M3 JUNCTION 9 NATIONALLY SIGNIFICANT INFRASTRUCTURE PROJECT

Written Summary of Oral Submissions

Issue Specific Hearings 1, 2 and 3

18 August 2023

PROJECT STAGE  
**PCF STAGE 3**

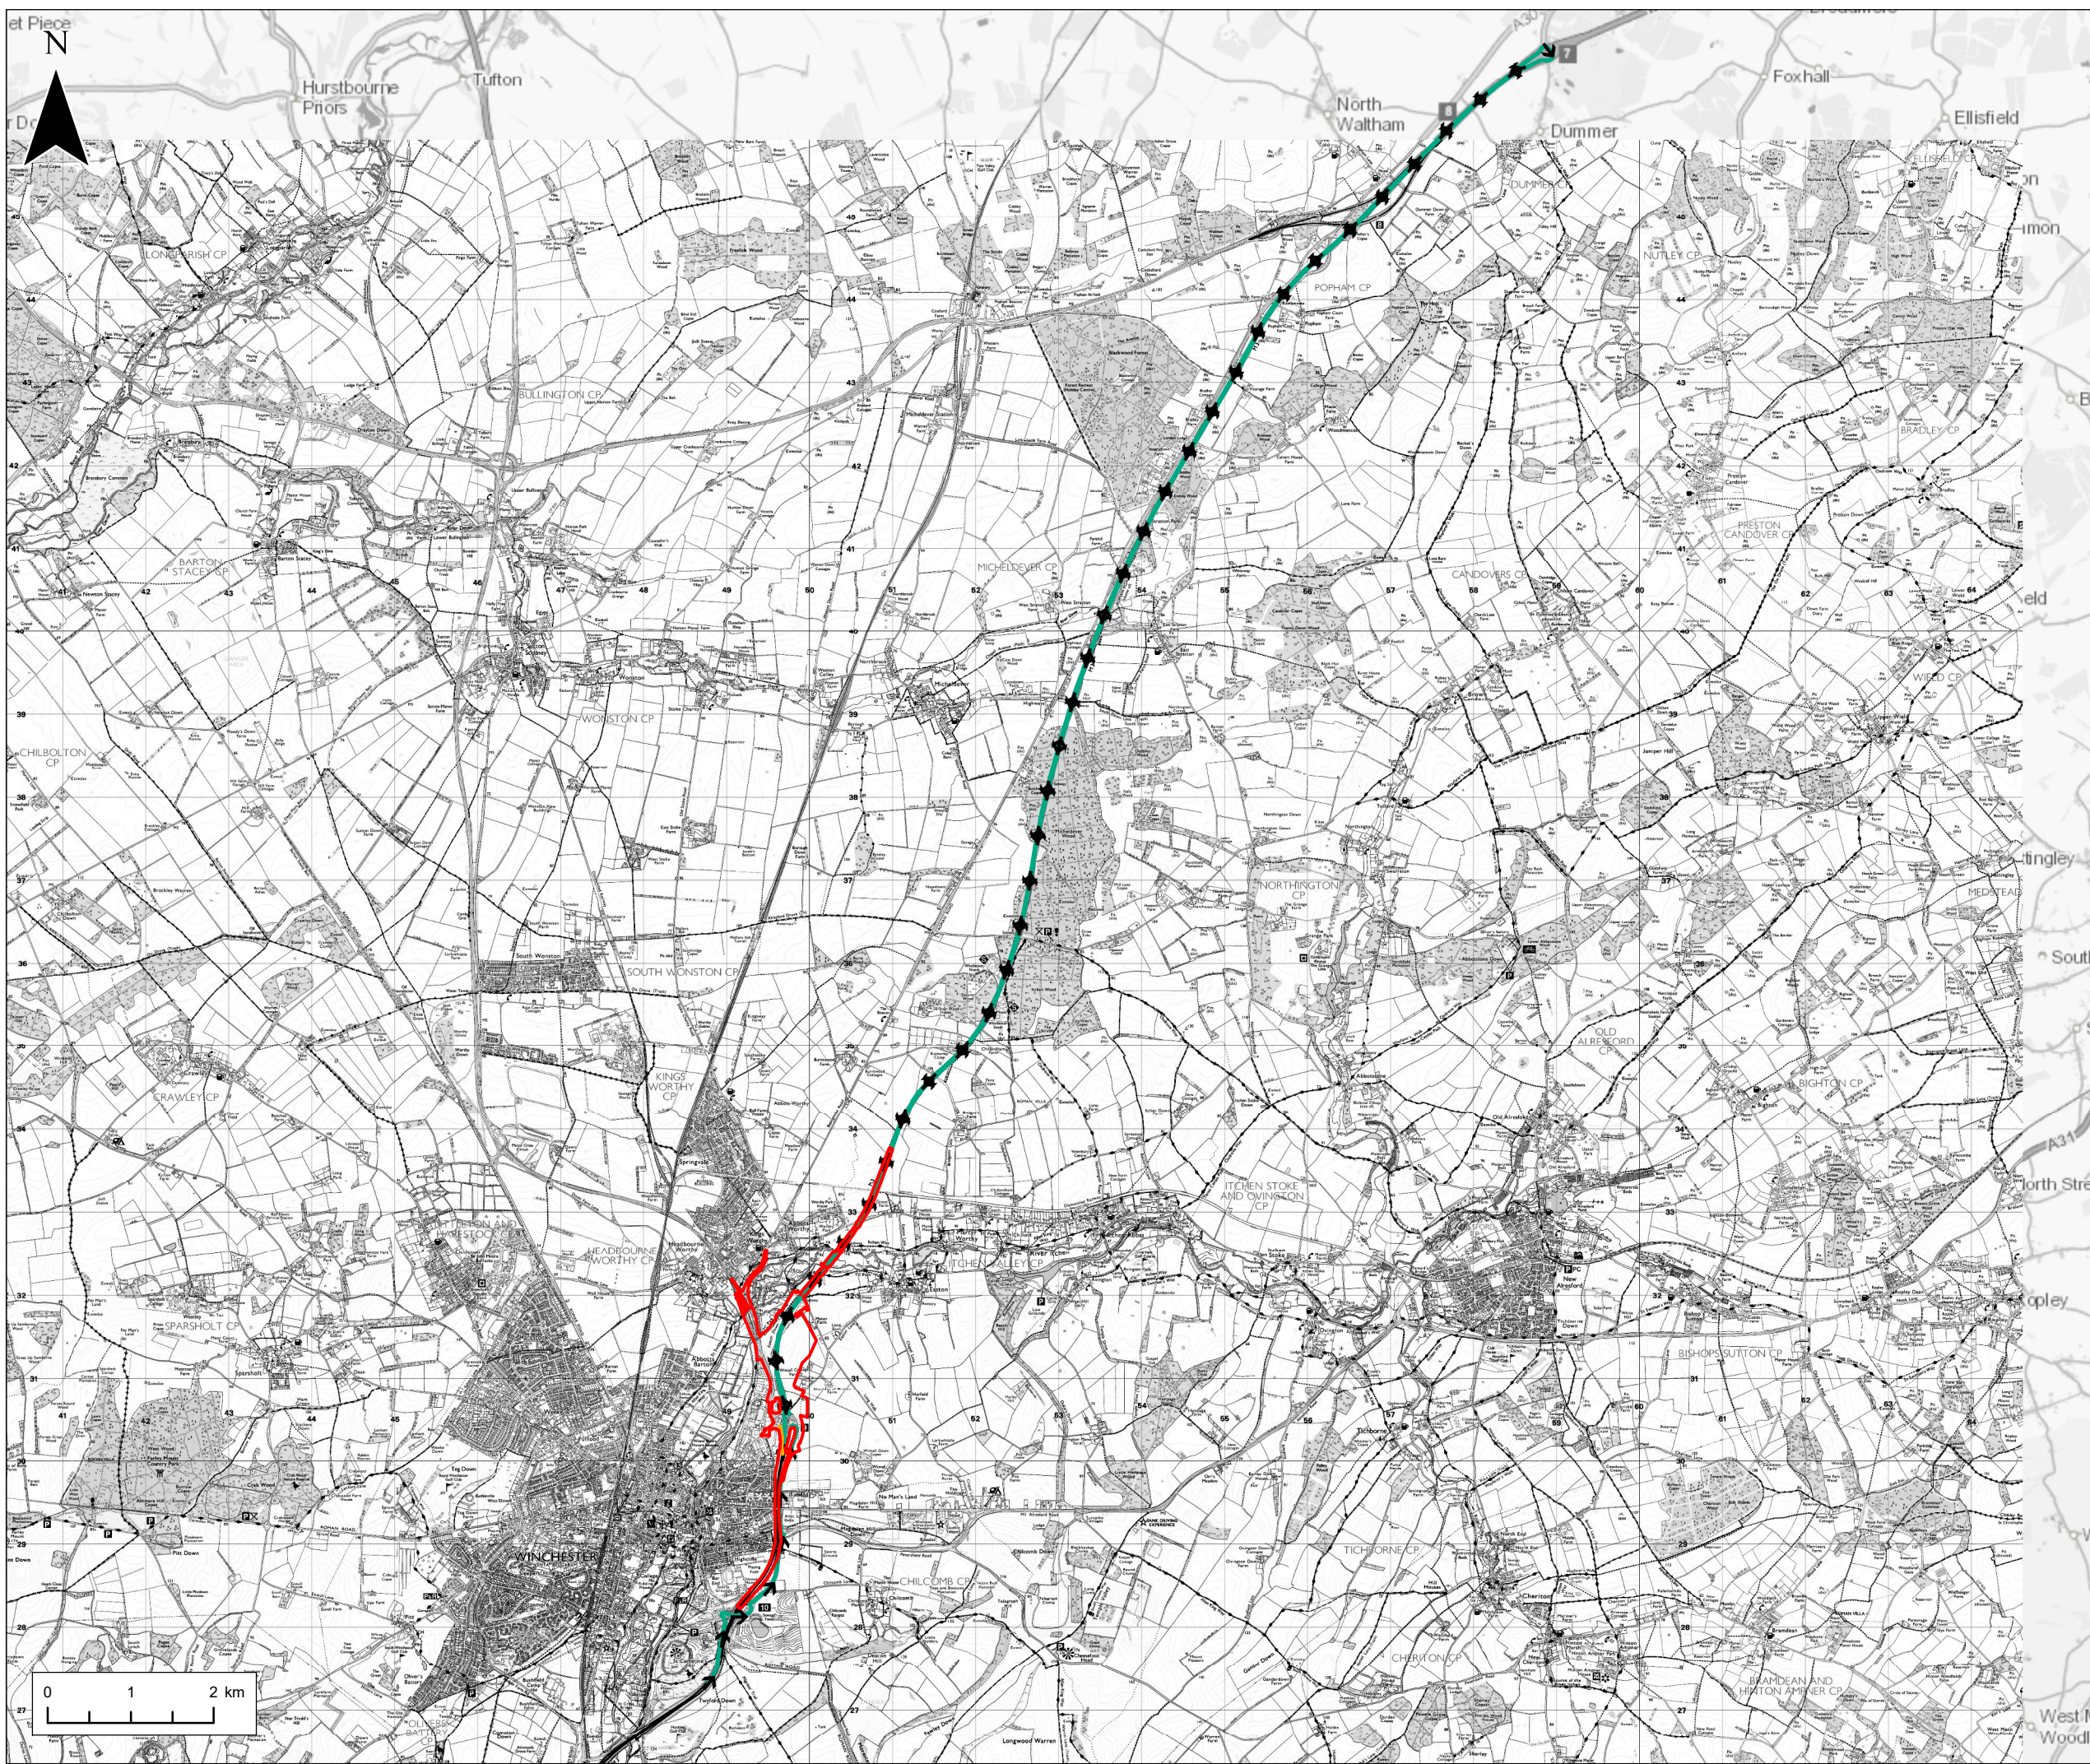
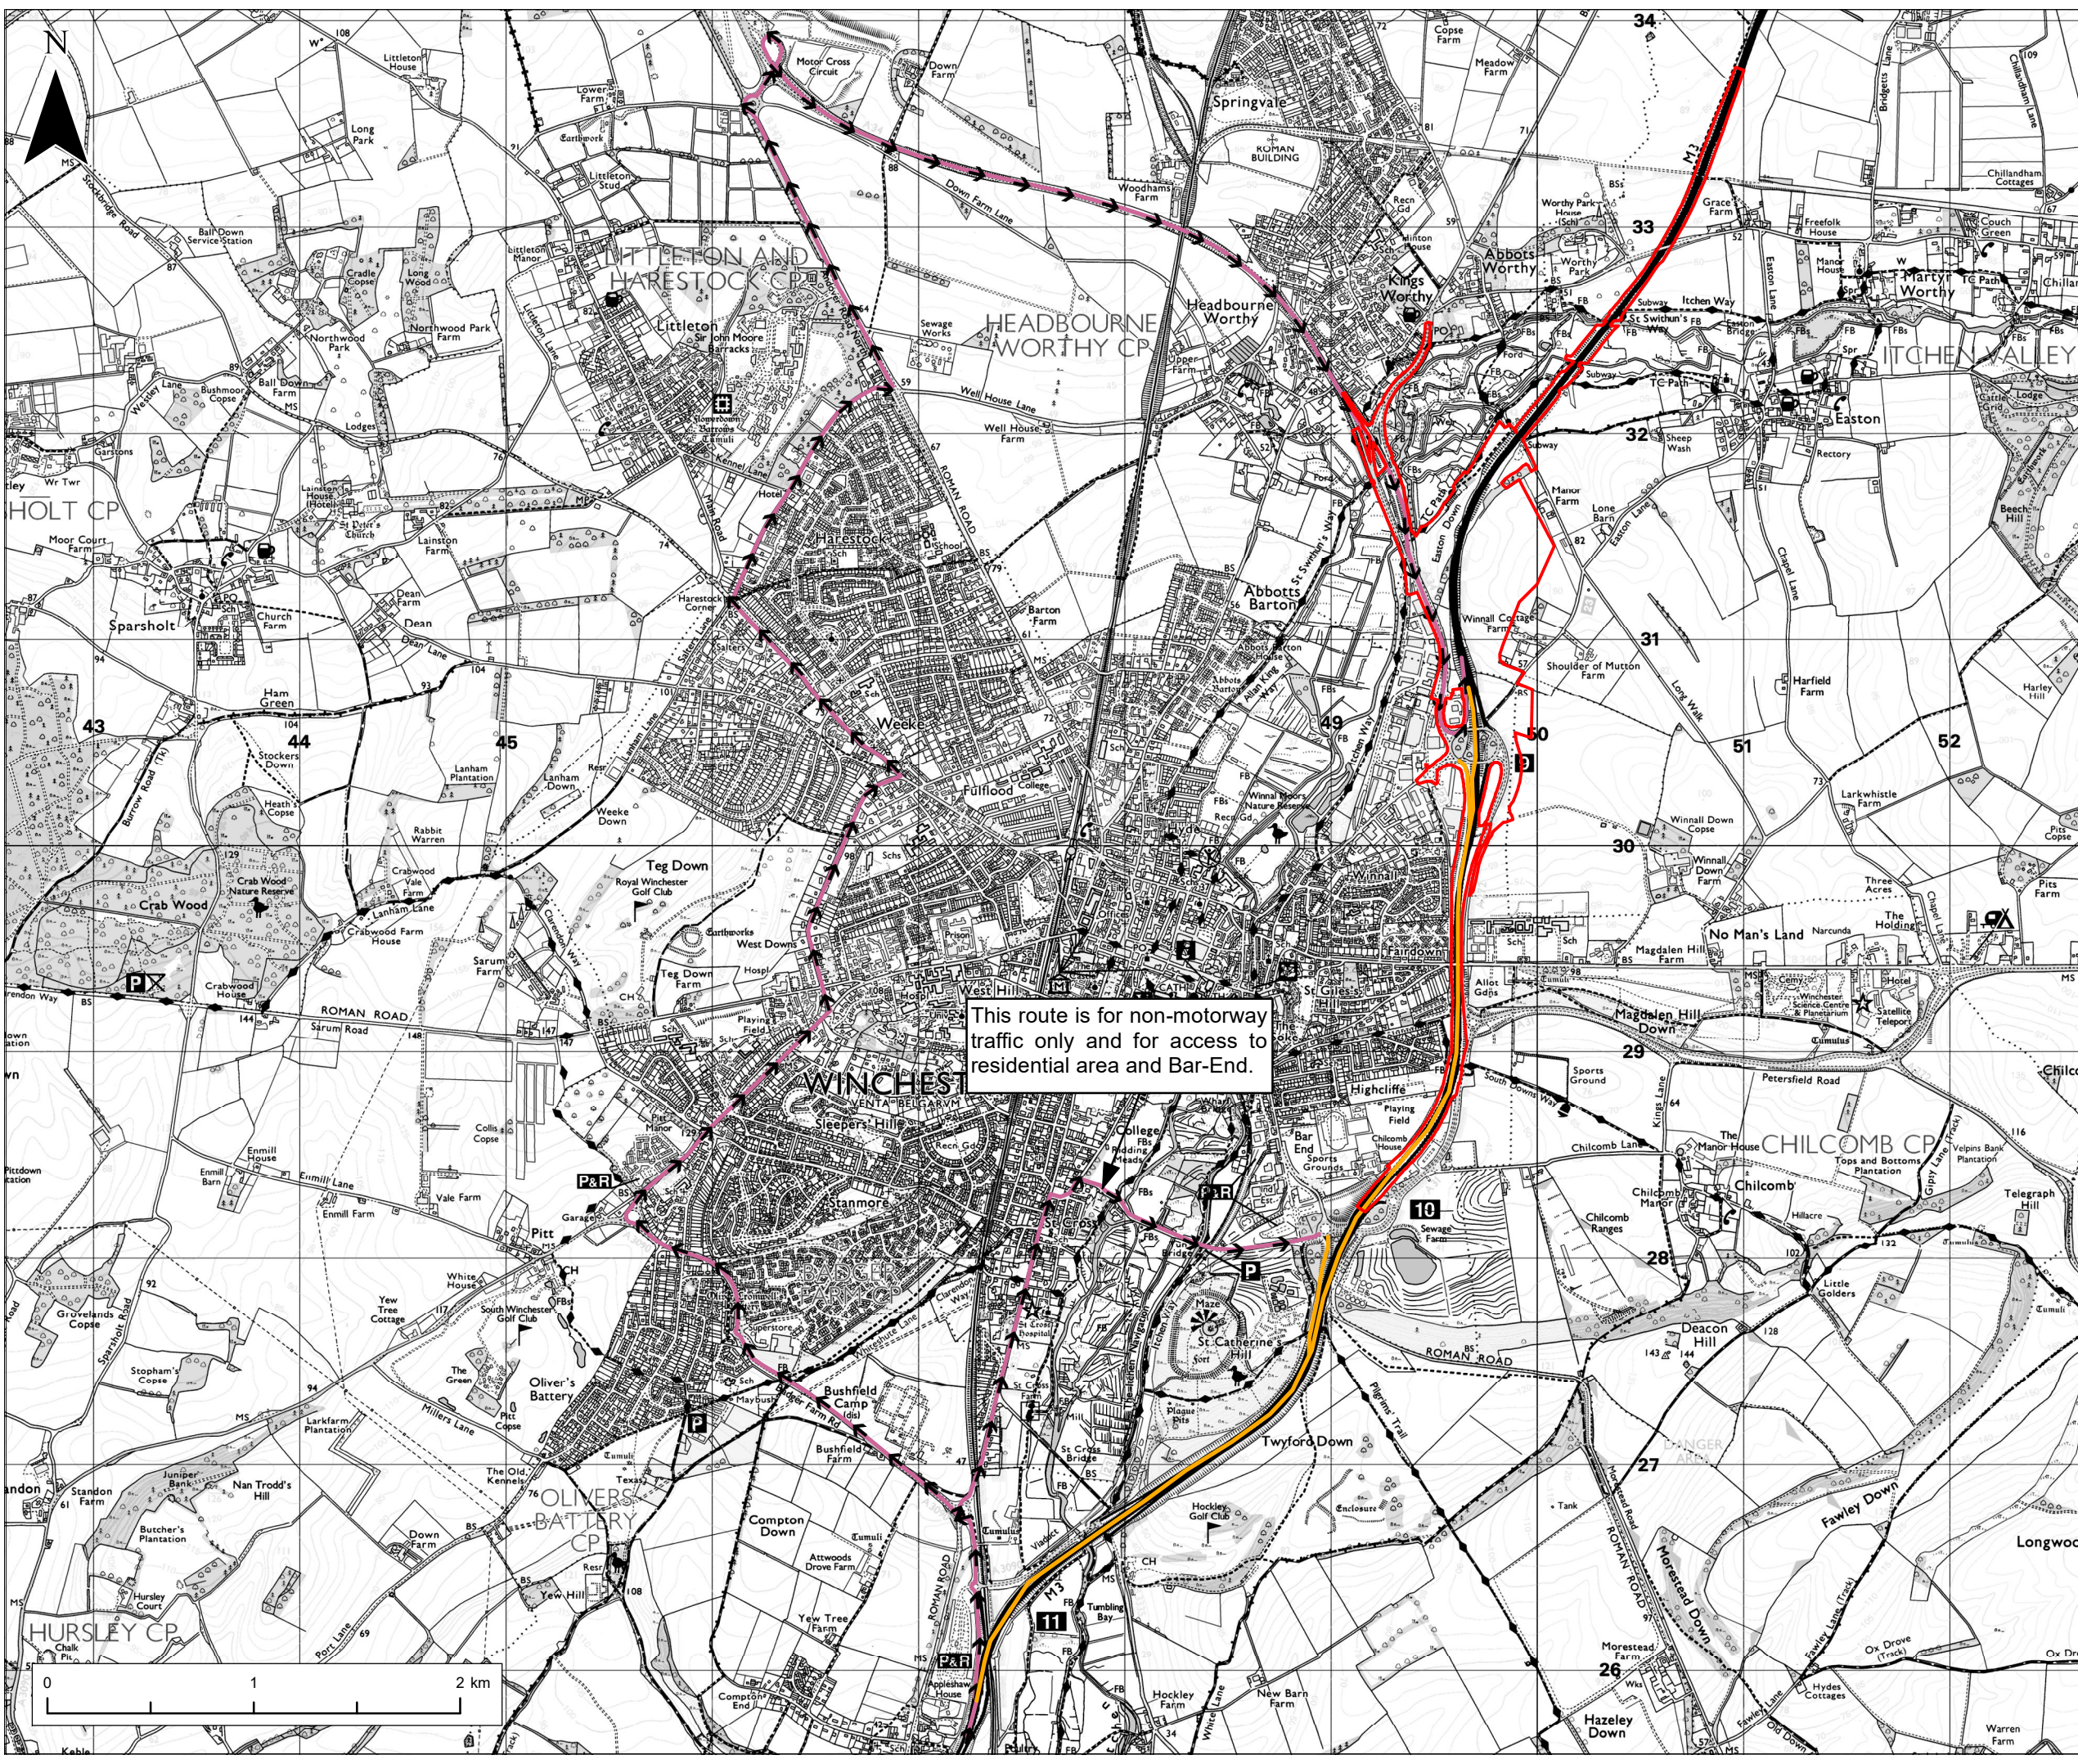
2.2.4 The City Council notes the points raised by the County Council and applicant during ISH2 which confirmed on-going discussions regarding appropriate diversion signage

(including advanced positioning, instructions not to follow sat-nav). The City Council has raised concern on the effectiveness of the diversion routes and will discuss this matter further with the County Council as Highway Authority.

2.2.5 Concerning the diversion of the Junction 9 northbound on-slip, which is required to travel southbound and then use Junction 11 for 17 months, the City Council concern relates to traffic signalling.

It is presumed that to accommodate the additional traffic using Junction 11, the signals for the M3 southbound off-slip traffic will be prioritised. This would result in increased delays for those held at traffic signals on the B3335 toward Twyford and along the Hockley Link. There is a significant pedestrian crossing on the Hockley Link serving the Itchen Way which will have to navigate the additional congestion.

The applicant confirmed at ISH2 that no traffic light alterations are proposed however this will be subject to monitoring. The City Council request clarification on the process which will be followed in the event that traffic signals are altered.
